Appendix I to the Relevant Representations of Natural England
Seascape Landscape and Visual

The construction and operation of the Five Estuaries Offshore Wind Farm located approximately 37km from the Suffolk Coast in the Southern North Sea.

Planning Inspectorate Reference EN010115

13 August 2024

Figure 10.34c  
 Viewpoint 9: Orfordness (Roof - Bomb Ballistics Building)  
 Five Estuaries

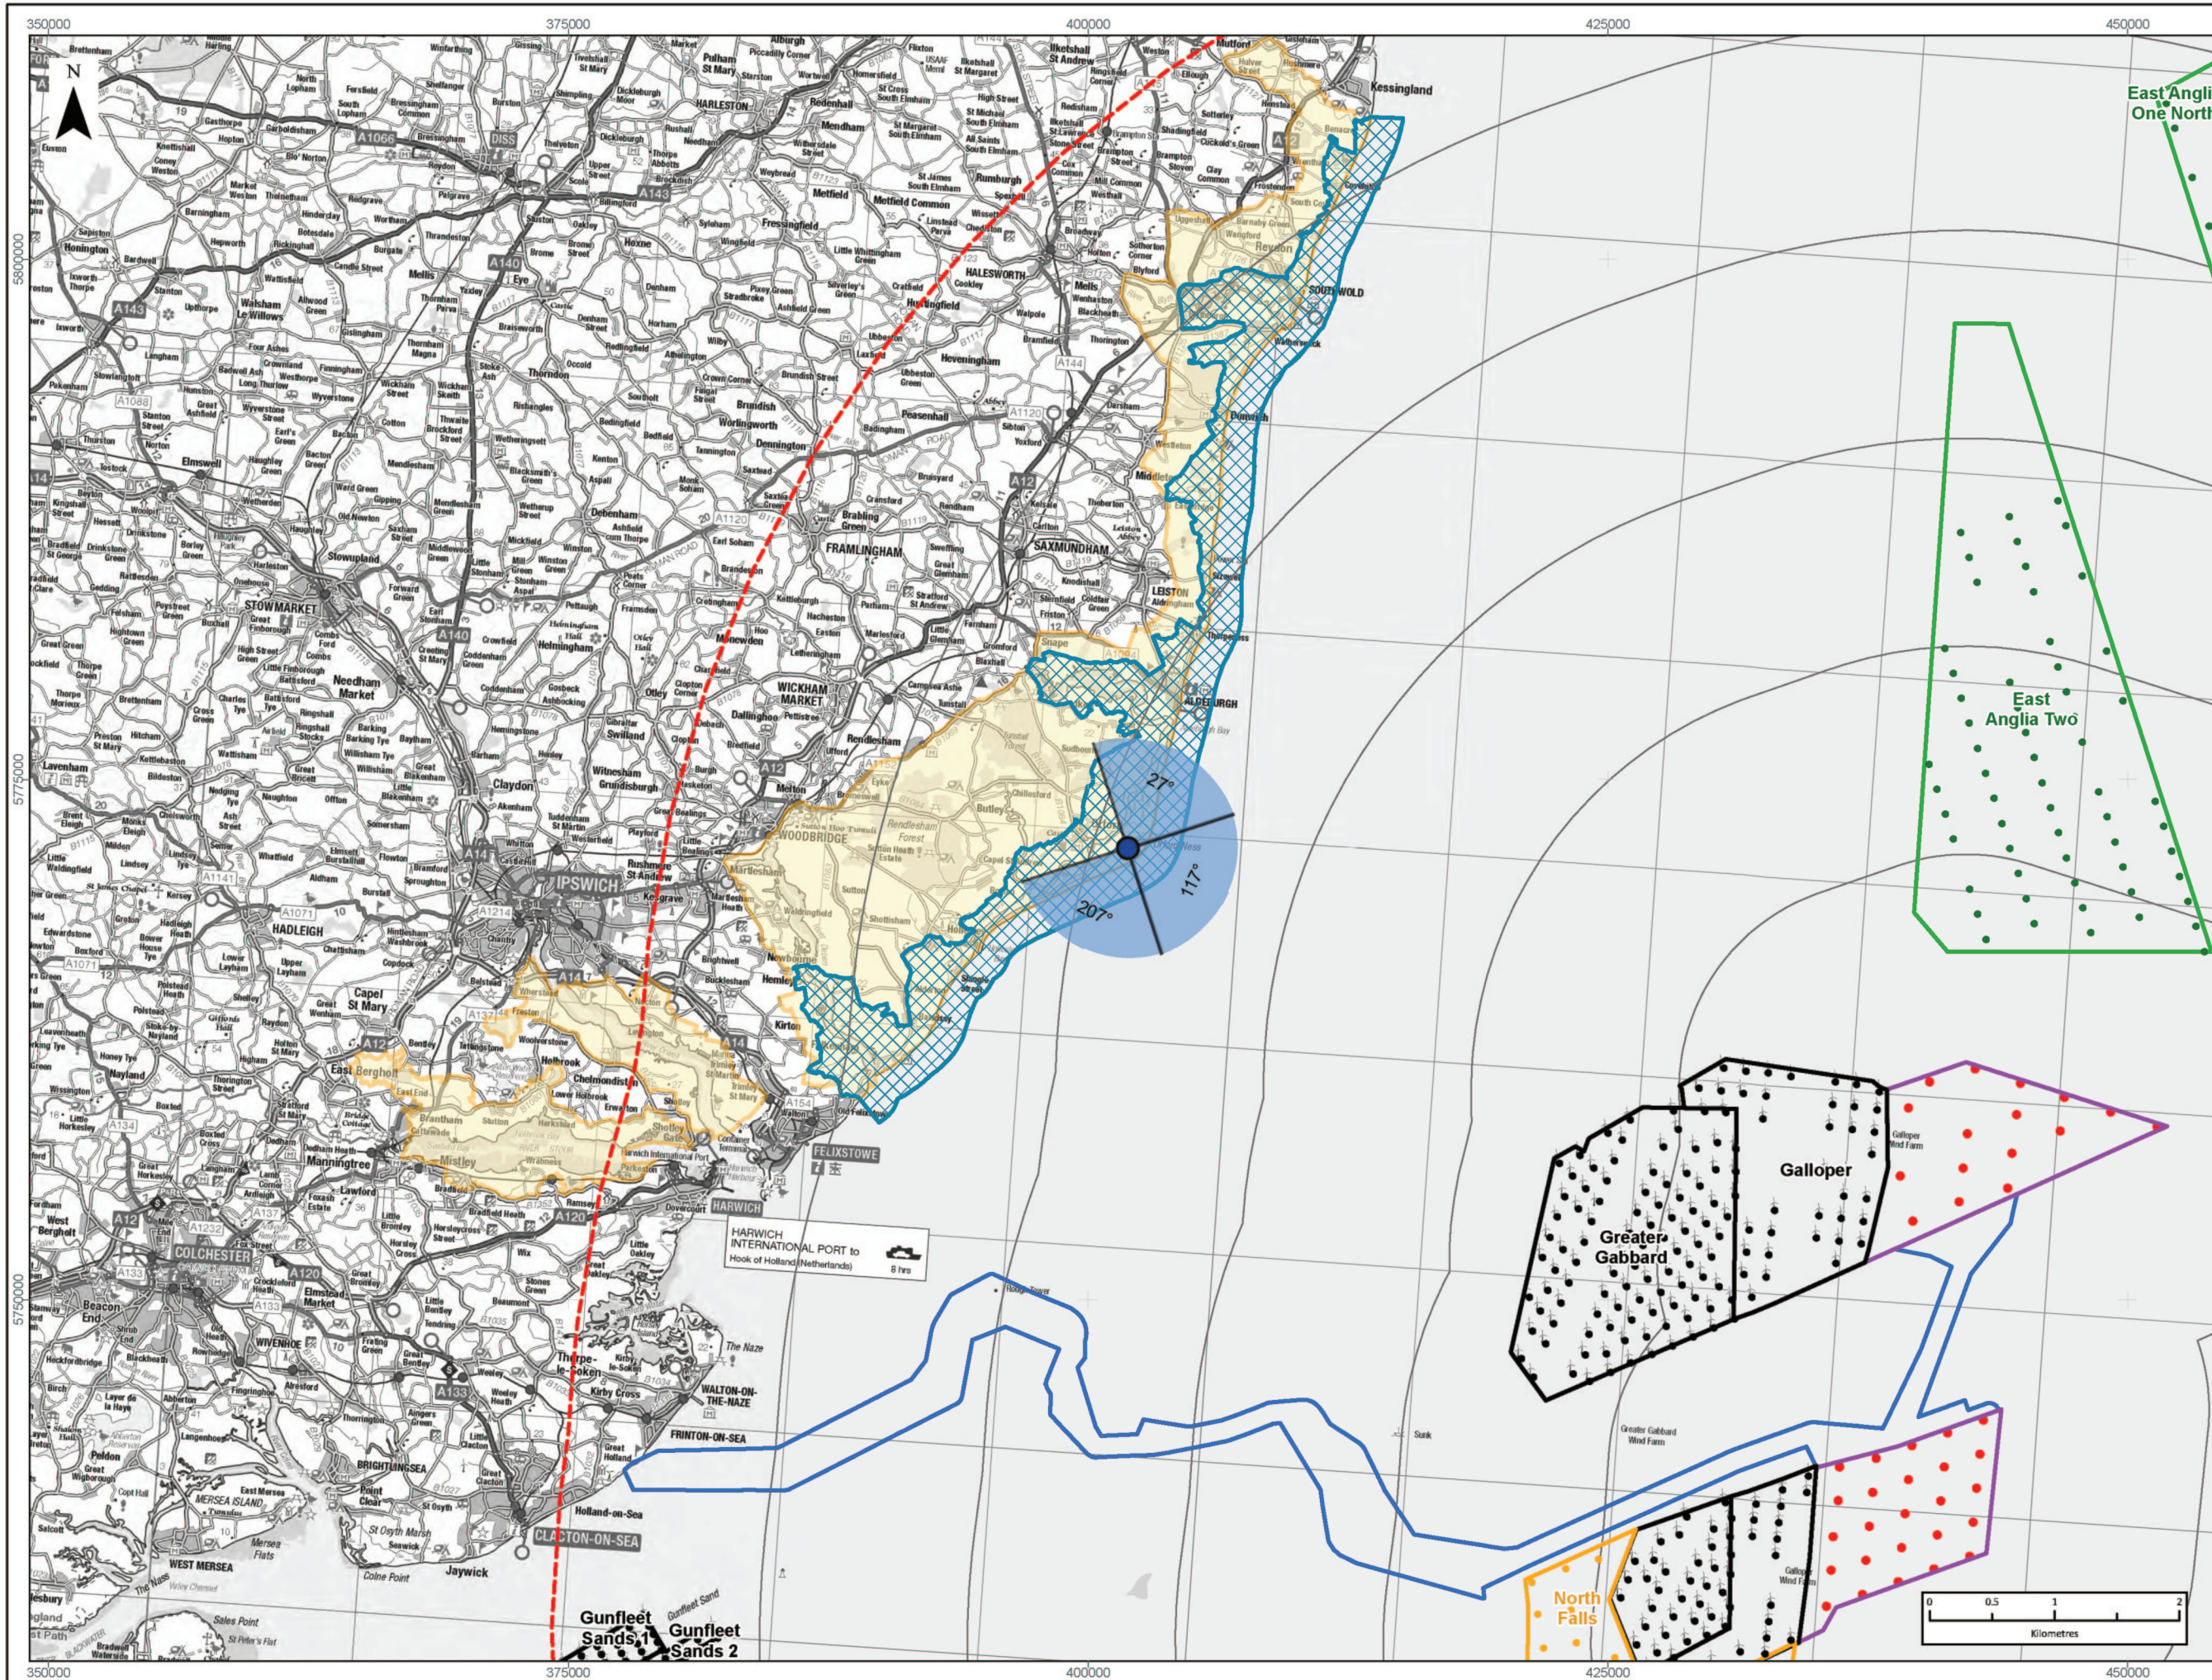
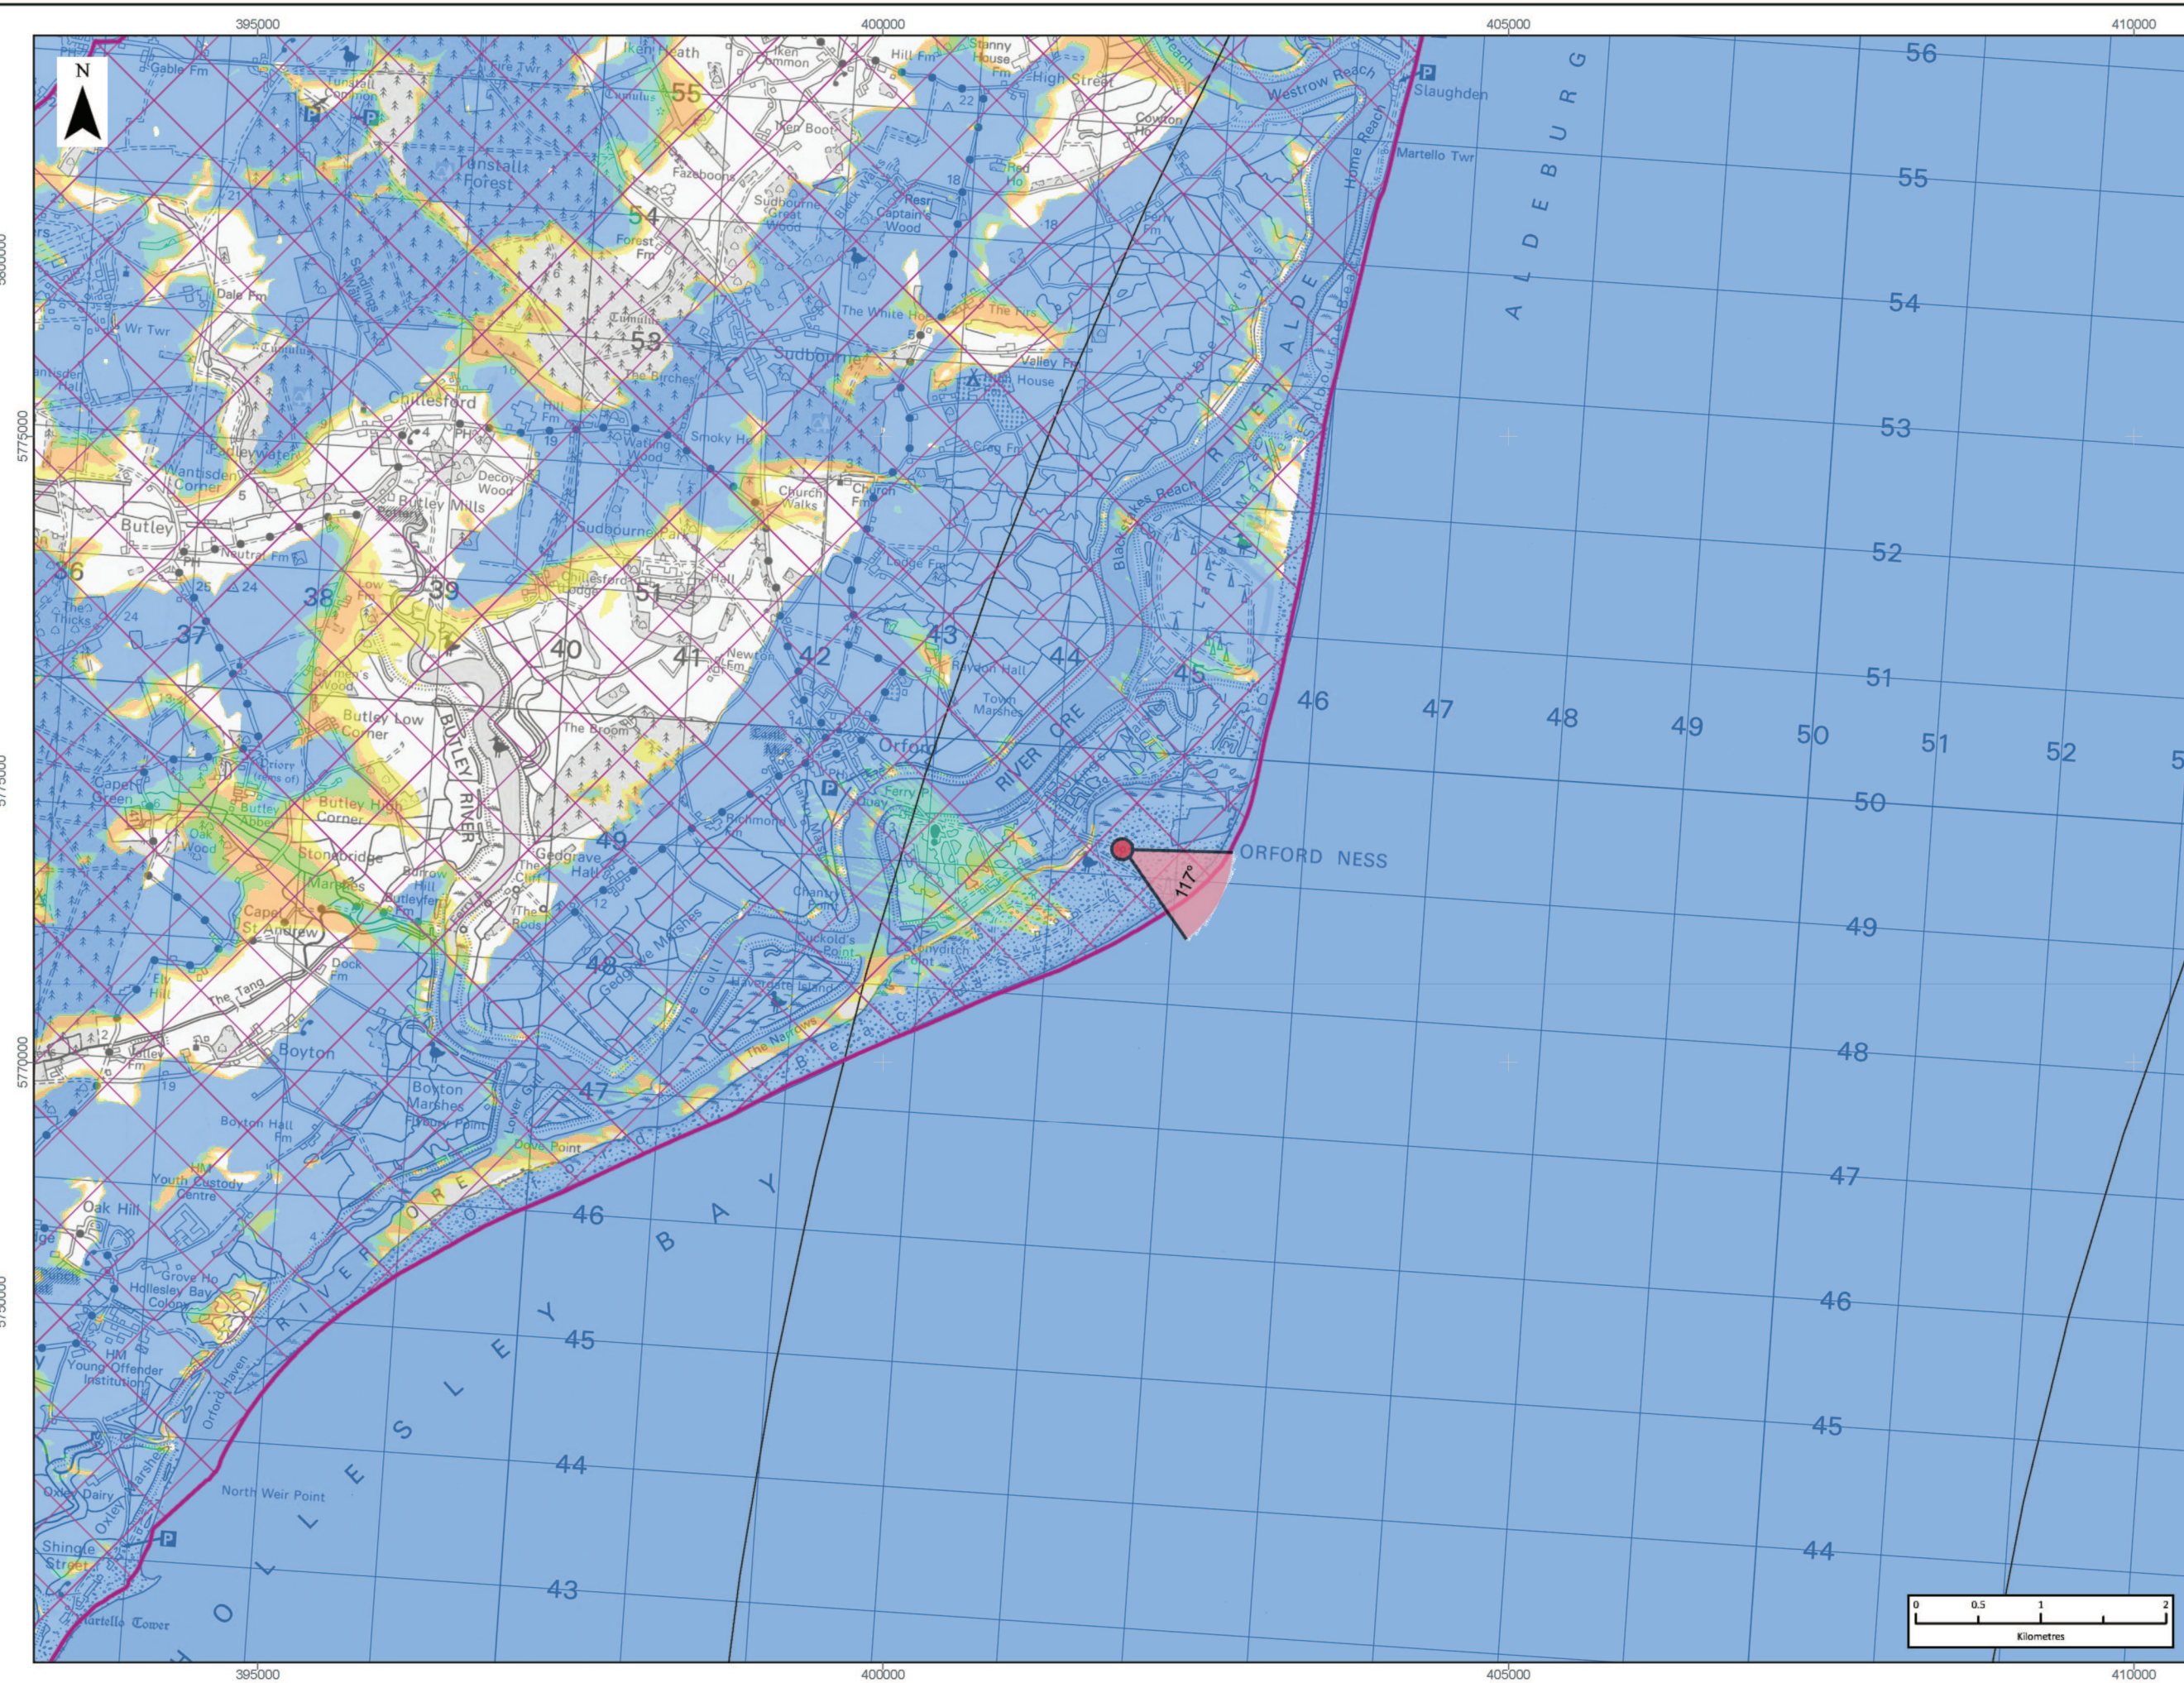
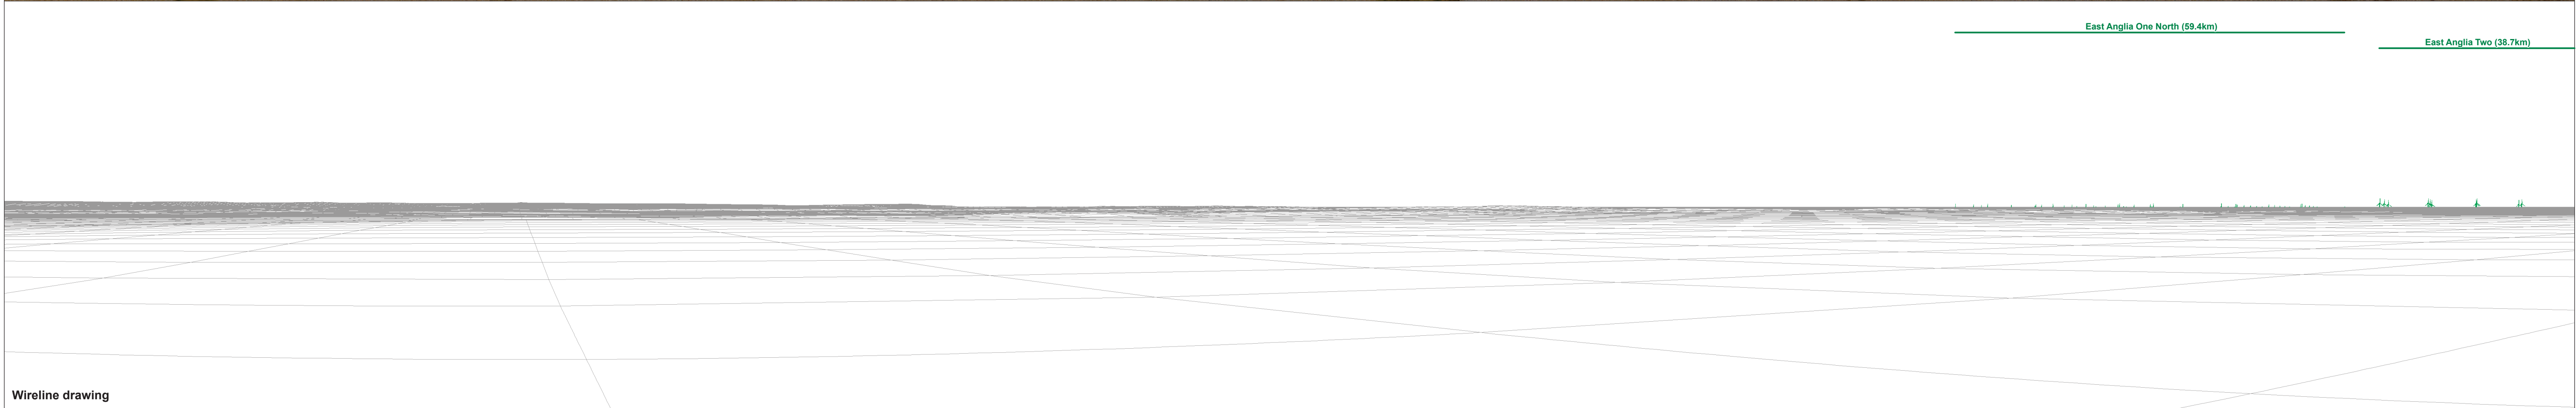
1.7 In particular, we draw the Examiners' attention to the value for the viewpoint located on **Orford Ness**, which should be considered in the context of the highly sensitive nature of this location, principally in terms of potential for significant adverse effects to the SCHAONB wildness and tranquillity special qualities.
